## KITTITAS COUNTY COMMUNITY DEVELOPMENT SERVICES

RE: Sullivan Short Plat, SP-14-00003

Enclosed are the comments received regarding the Sullivan Short Plat (SP-14-00003) during the comment period:

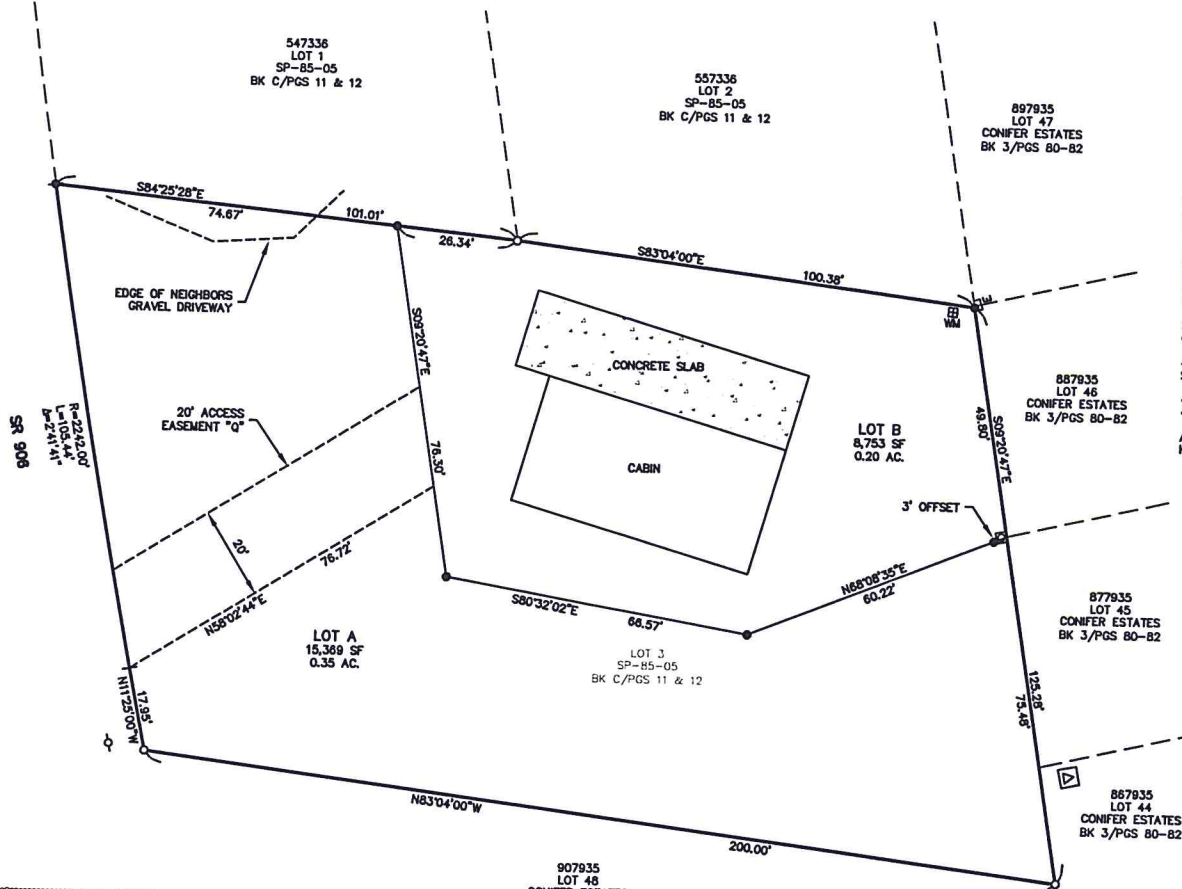
- The subject property is adjacent to State Route 906 (SR 906), a Class 4 managed access highway with a posted speed limit of 35 miles per hour. The subject property is permitted (permit #2725) to have an approach at milepost 0.99 left; however, it appears this approach has been relocated further to the south (milepost 1.03 left). The property owner is required to contact Mark Kaiser of the WSDOT – South Central Region Office at (509) 577-1668 to update the permit.
- Snow storage is an ongoing issue with WSDOT. Any snow accumulated on these properties shall not be moved onto WSDOT rights-of-way. We encourage the proponent and future residents to not underestimate the potential for large volumes of snow and designate a snow storage area on the property.
- Parking will not be permitted within WSDOT rights-of-way.

- The access/driveways for the properties to be created were not noted on the plans submitted. Any driveway greater than 150' in length shall be 16' in width. Driveways less than 150' shall be no less than 12' in width.
- The addresses shall be posted at the front of the property and easily visible from the road to emergency responders.
- Due to the small nature of these lots, LP-Gas propane tanks will not be allowed for these lots.
- Any new structures or substantial development to existing structures will require a WUI permit.
- All future development must comply with the International Fire Code.

1. Access: Access to this property is from SR 906. Comments from WSDOT require the applicant to contact Mark Kaiser to update the existing access permit. The access permit must be approved prior to final approval of the short plat.

2. Access Easement: Current road standards require a minimum 20' width driveway easement. A minimum of 30' is recommended in order to provide snow storage during the winter season.

3. Joint-Use Driveway: A joint-use access shall serve no more than two tax parcels. See Kittitas County Road Standards, 9/6/05 edition.
  - a. Access easements shall be a minimum of 20' wide. The roadway width shall have a minimum width of 12'.
